Your ref:
Our ref: 23/01499/F
Please ask for: Miss Sandra Homcenko
Direct dial: 01553 616824
E-mail: borough.planning@west-norfolk.gov.uk

Details: **Single storey extension to dwelling at Glenmoray 121 Main Road West Winch King's Lynn Norfolk**

I have received a planning application as detailed above but cannot process it until I receive some more information:

121, MAIN ROAD, WEST WINCH,  
KING'S LYNN, PE33 0LP

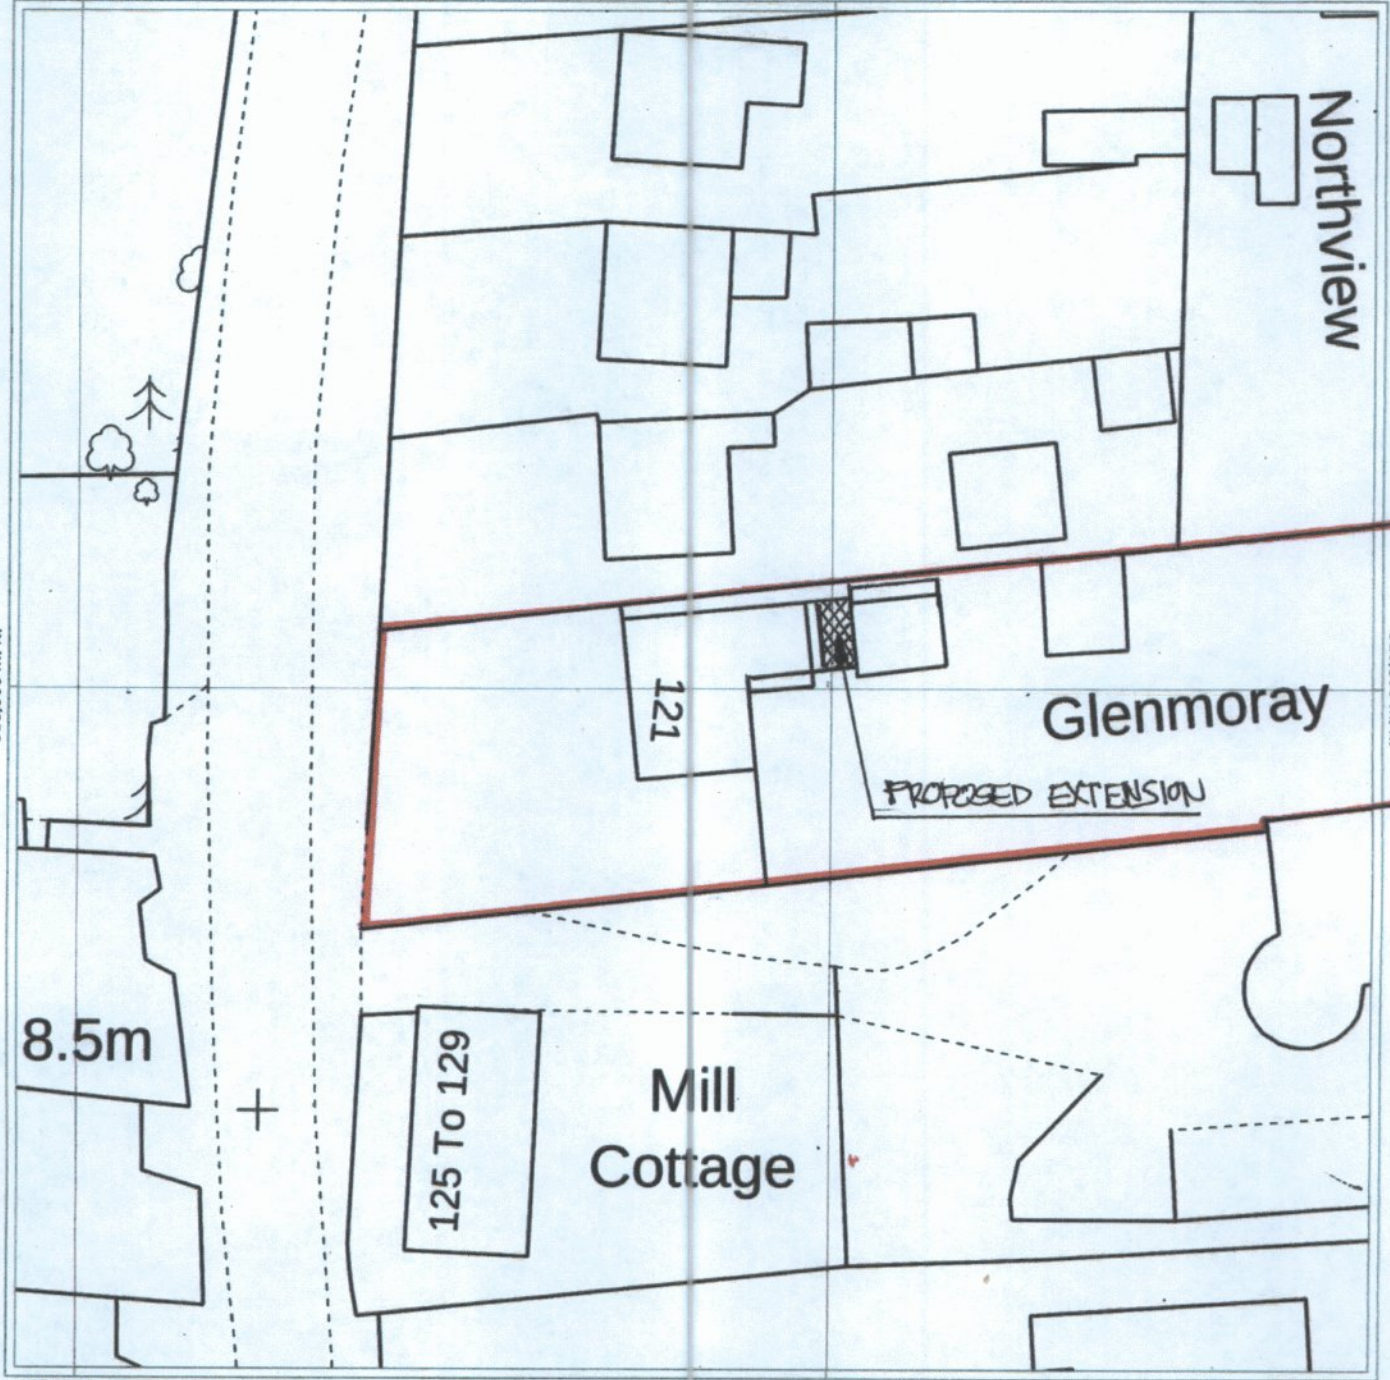
2. The red line on the location plan is incomplete, if the site is too large for scale 1:1250 then we also accept plans to scale of 1:2500 or 1:5000.
